Online Comment

Application H17-0216-21
Location 15 THE RESERVOIR SURFLEET SPALDING PE11 4DH
Proposal Demolition of existing dwelling and erection of new dwelling

Name Ian Marshman, Historic Environment Officer
Address Lincolnshire County Council Lancaster House 36 Orchard Street LN1 1XX

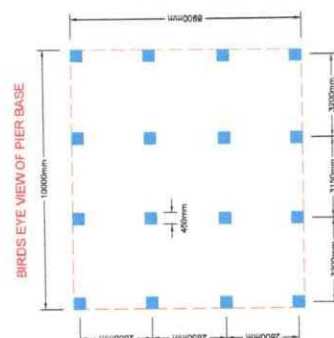
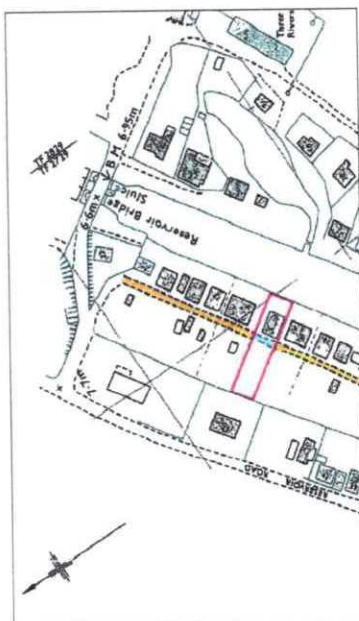
The present building which it is proposed to replace is typical of the historic chalets that make The Reservoir distinctive, with its use of natural wood and metal roof sheeting. Although later extended with a flat roof construction the original chalet facing The Reservoir is still recognisable, and with its pitched roof and brick chimney stack is characteristic of the simple 'handmade' and repurposed construction which has made the areas so distinctive.

PLOT 15, RESERVOIR ROAD
SURFLEET
(PROPOSED LAYOUT)

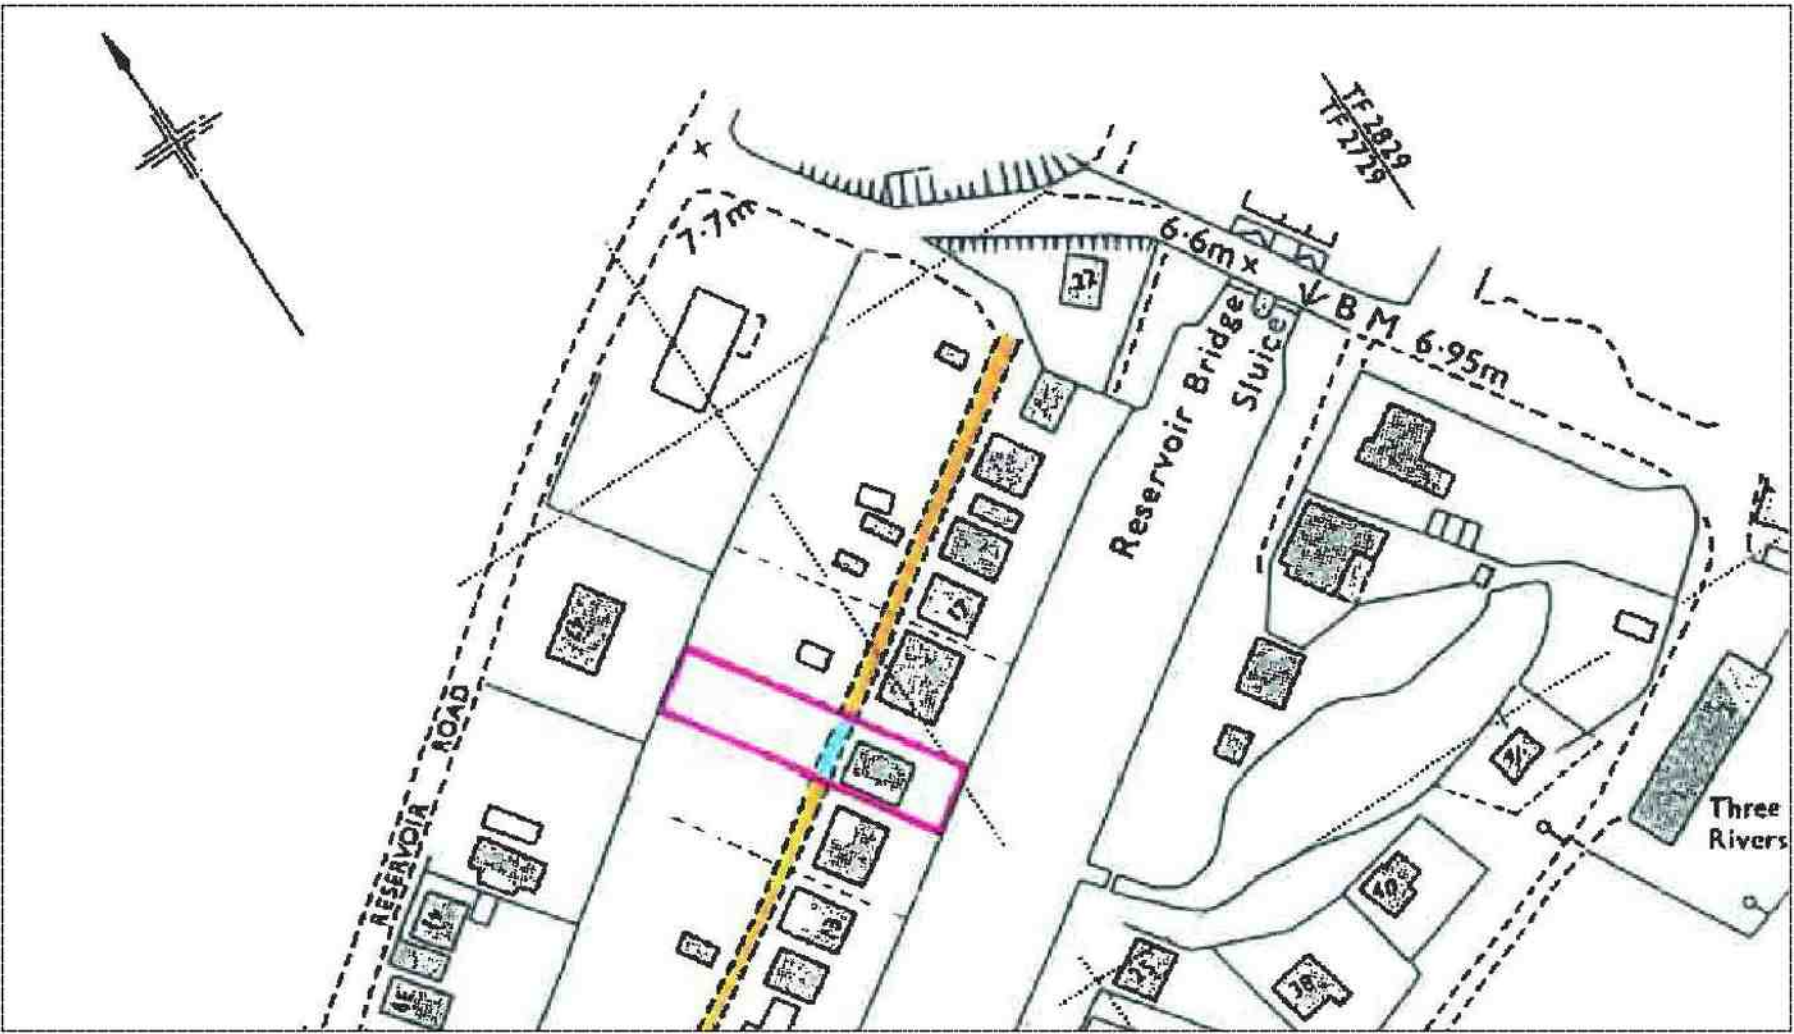
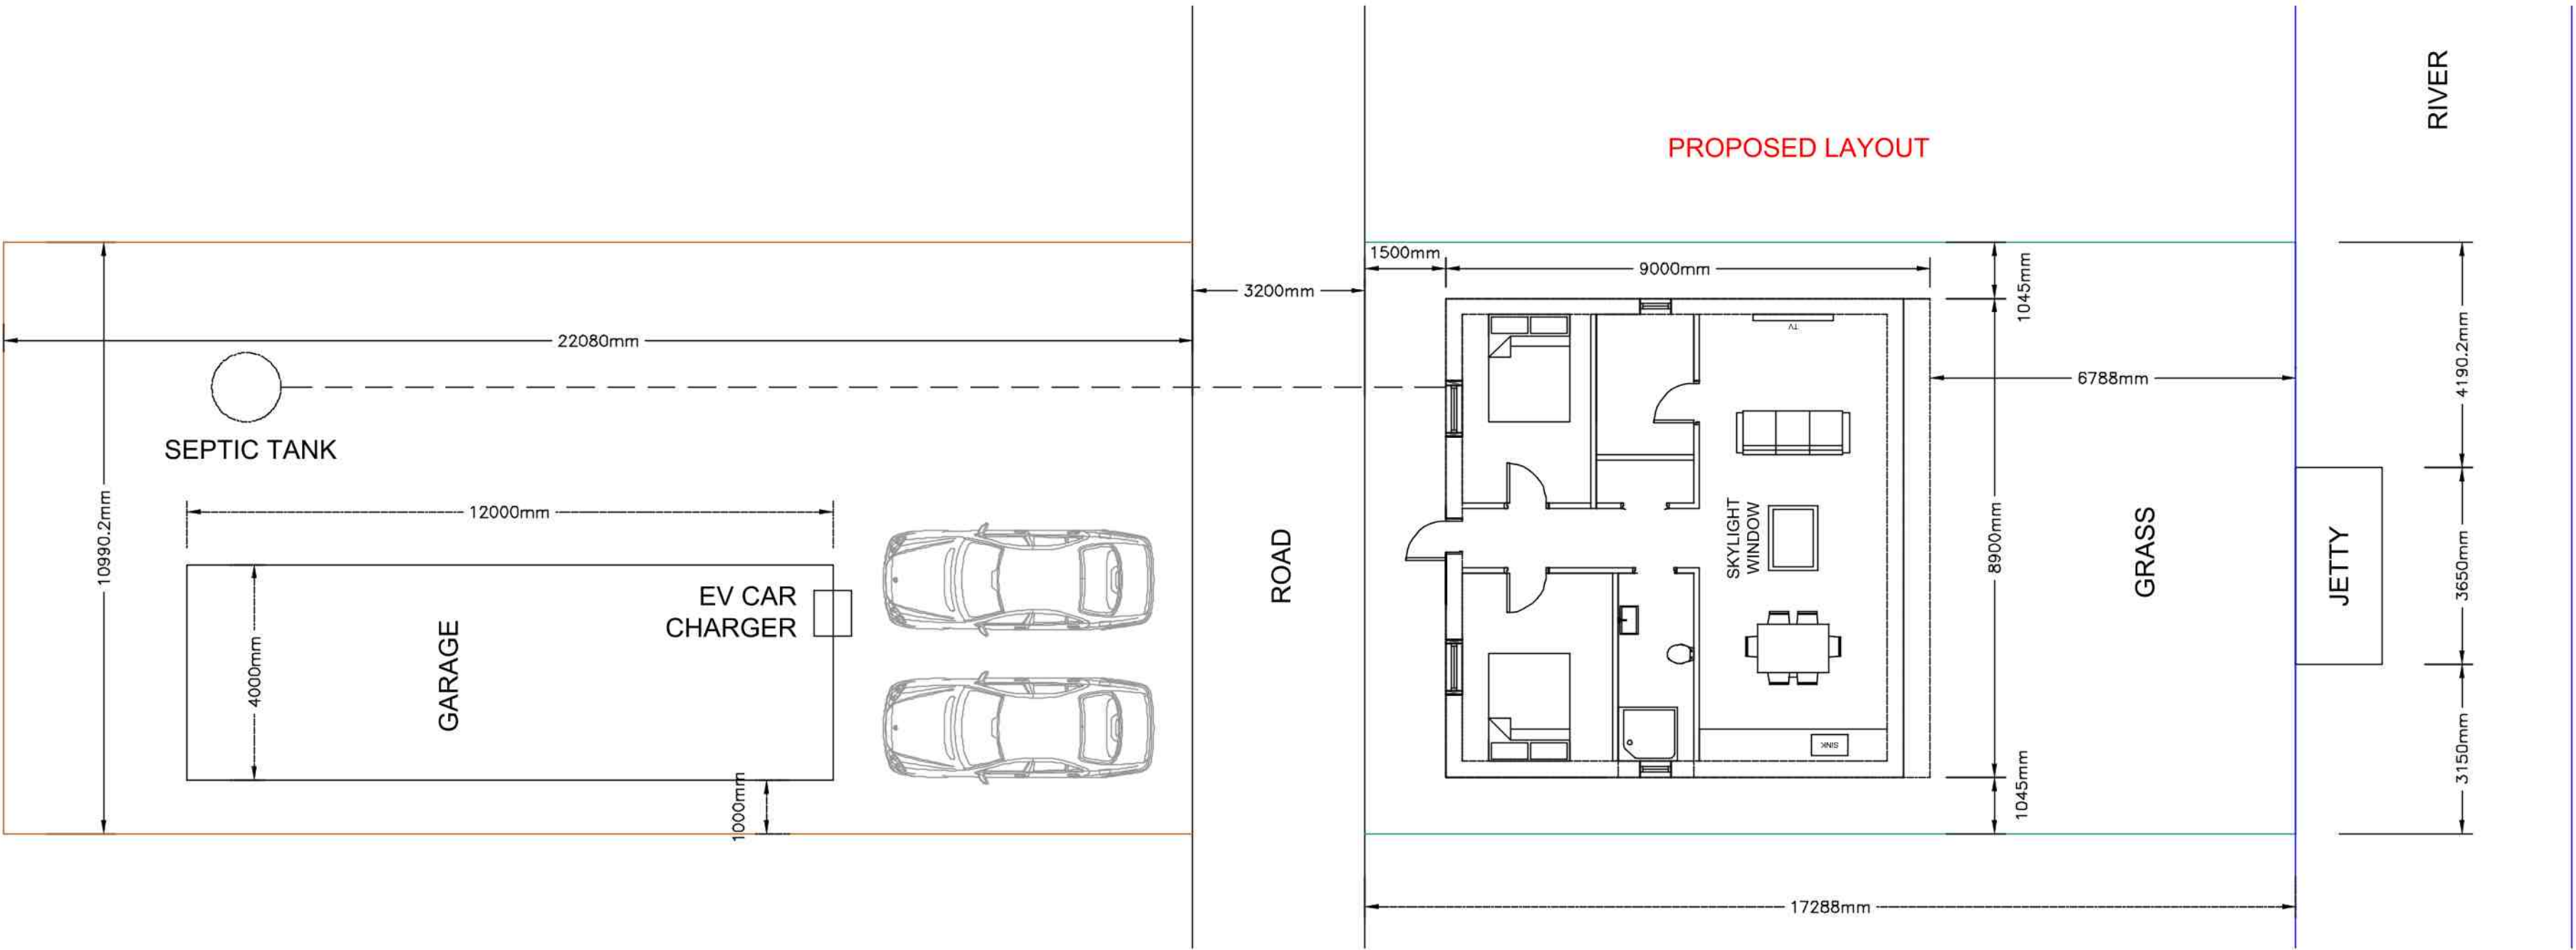
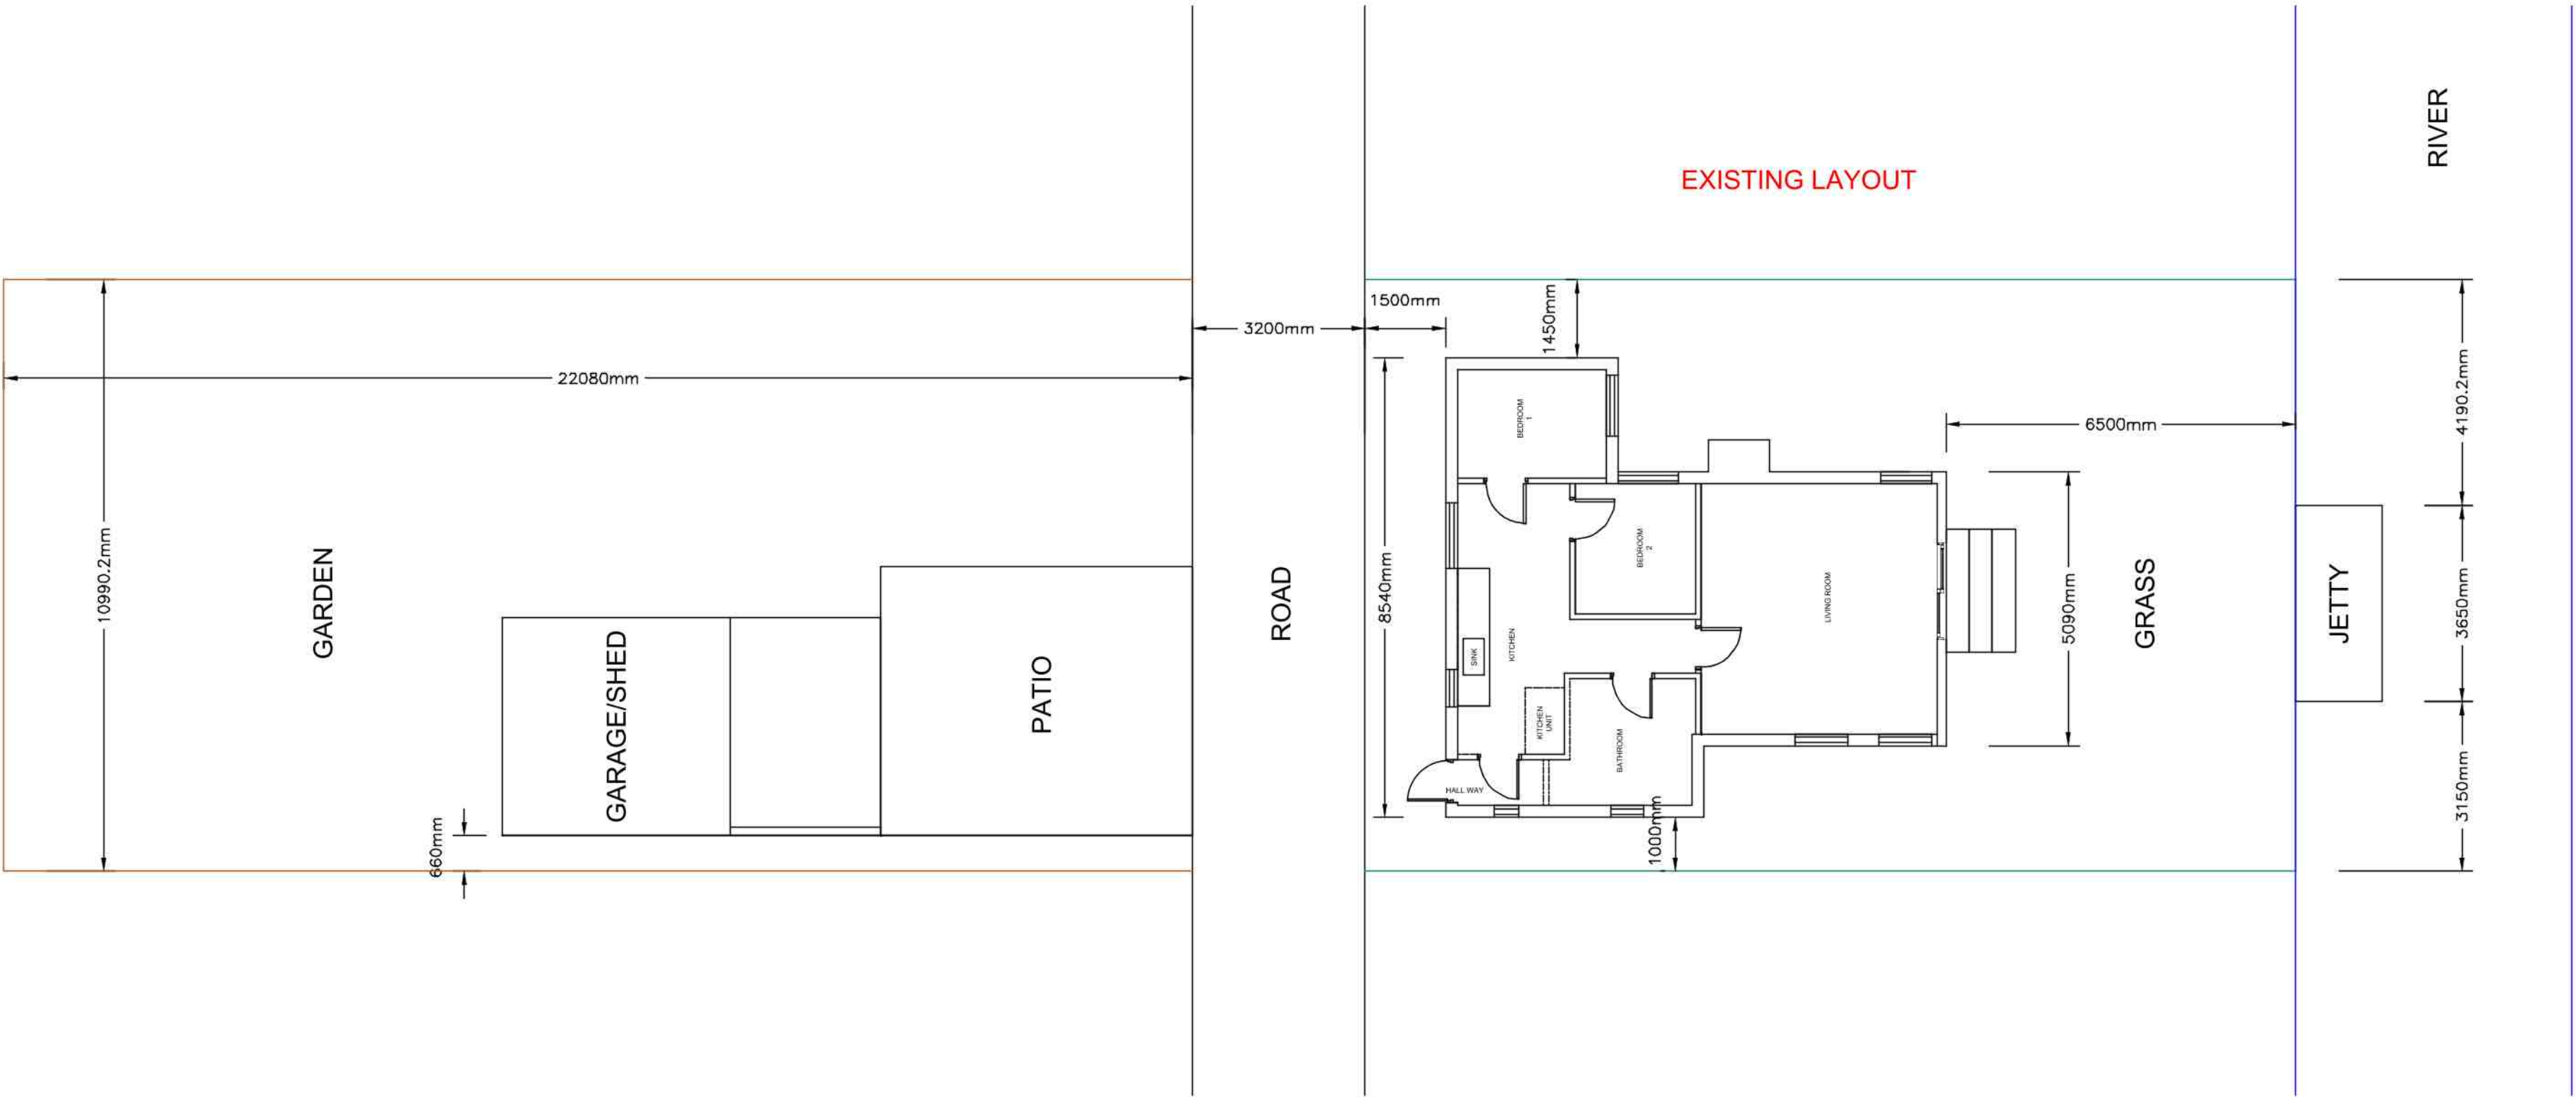
We recommend that the impact of the proposed modern design and materials of any replacement dwelling is carefully assessed by the local planning authority and its impact on the unique character of The Reservoir considered, with input from the Conservation Officer if necessary.
